**KIRKLEES METROPOLITAN COUNCIL
INVESTMENT & REGENERATION SERVICE**

Reference No: 2018/60/93013/E

Site Address: 81 , Huddersfield Road, Skelmanthorpe, Huddersfield,
HD8 9AR

Description: Outline application for demolition of existing dwelling
and erection of residential development of four
dwellings.

DRAWING TITLE
PROPOSED SITE PLAN

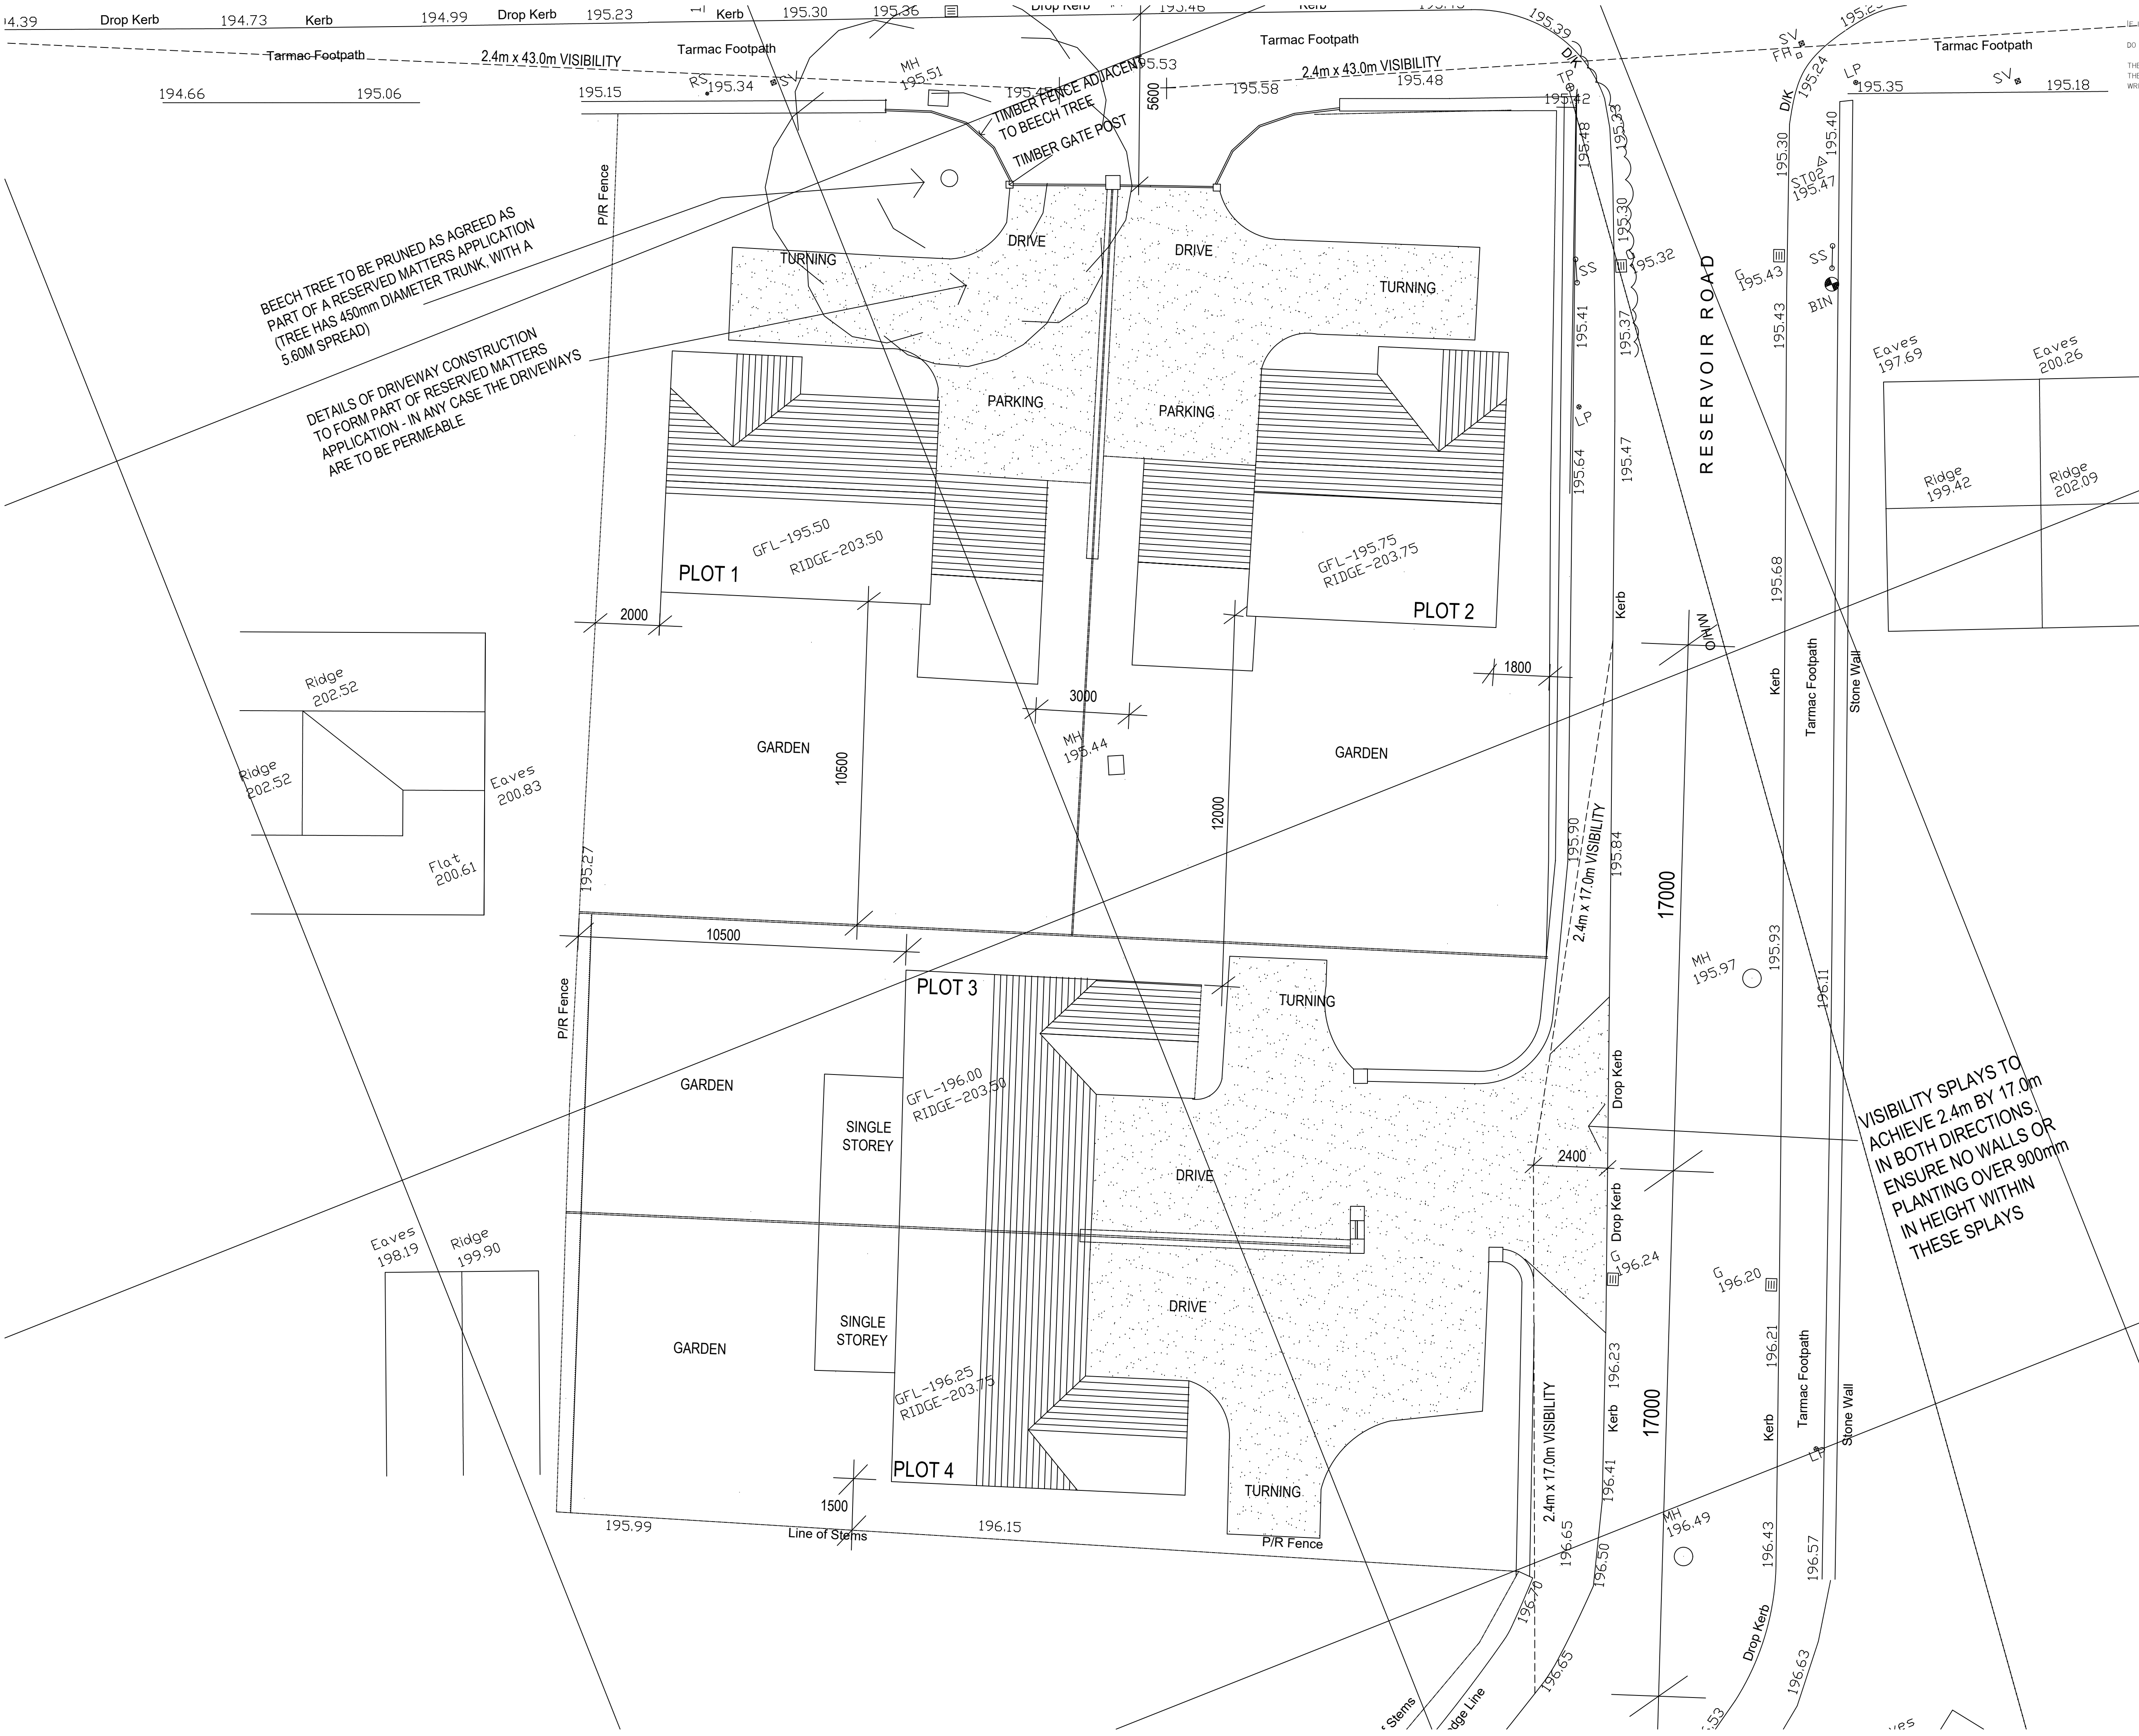
Changes have taken place during the course of this application to protect a Beech tree adjacent to Huddersfield Road and the proposed new access in that area; alter the access onto Reservoir View to improve highway safety; join plots 3 & 4 to form a pair of semi's, which is more in keeping the existing type of housing at Reservoir View; and defer details of 'scale' from consideration at this stage, this will be a reserved matter.

- K C Highways (Development Management):
Initially objected on road safety grounds due to visibility splays at the access on Reservoir View. Following amendments to the drawings to alter the point of access to plots 3 & 4, the addition of acceptable sightlines to both accesses and in light of the results of some speed surveys being carried out, the Highways officers were able to support the scheme subject to conditions.
- K C Ecology unit:
No objections.
- K C Trees:
Served a Tree Preservation Order on the owner of the land to protect a Beech tree at the proposed new entrance onto Huddersfield Road. Supported the proposal after receipt of an arboricultural method statement and amended plans that showed the footprint of plot 1 further away from, and outside of, the crown spread of the protected Beech tree.

In relation to the former, the rear building line of the footprint to plot 1 would be approximately in line with the front elevation of this neighbouring property and the nearest corners would be around 5.7m from each other. Whilst scale and appearance are reserved matters, it is envisaged that a house in this position could cast some shade, but that this would be over the front garden which is already overshadowed to some extent by the existing house at 83, Huddersfield Road. Any overbearing impact would also be mitigated to some extent by the separation distance.

The expected rear elevation of plots 3 & 4 are parallel to the boundary with 83, Huddersfield Road, however, the main part of this pair of semi's would be at least 10.5m from the mutual boundary with single storey elements approximately 2.5m closer. Given this separation distance and that there would be no direct relationship expected between habitable room windows, it is considered that the impact upon residential amenity would be acceptable.

In relation to 16, Reservoir View, this is a chalet style bungalow with dormers to the front and rear. It is located to the south west of the application site and its side elevation is at an angle to the mutual boundary. Plot 4 would be close to the mutual boundary and is likely to have some overbearing impact, but as it is largely to the north, it is expected that it would not block much direct sunlight. There would be no direct relationship between existing and expected

Amended plans were submitted to address comments from Highways Development Management. This has narrowed the entrance gateway to plots 3 & 4, onto Reservoir View to increase the distance between the access to these properties and a bend in the road, to improve sight lines and highway safety. In addition some speed surveys were carried out and the sightlines added to the amended plan.

At the time of the officer site visit there were a variety of shrubs and trees forming quite a dense hedge around the perimeter of the site. A Beech tree near the existing entrance from Huddersfield Road was subsequently protected with a tree preservation order. As a result an arboricultural method statement (AMS) was submitted and the proposed layout altered so that the footprint of plot 1 would be outside the crown spread of the TPO'd tree.

8. Before any dwelling is first occupied turning facilities shall be provided in accordance with the details shown on drawing no. 01 rev E. The turning facilities shall thereafter be made available for use at all times by vehicles and shall be kept free from obstruction to such use.
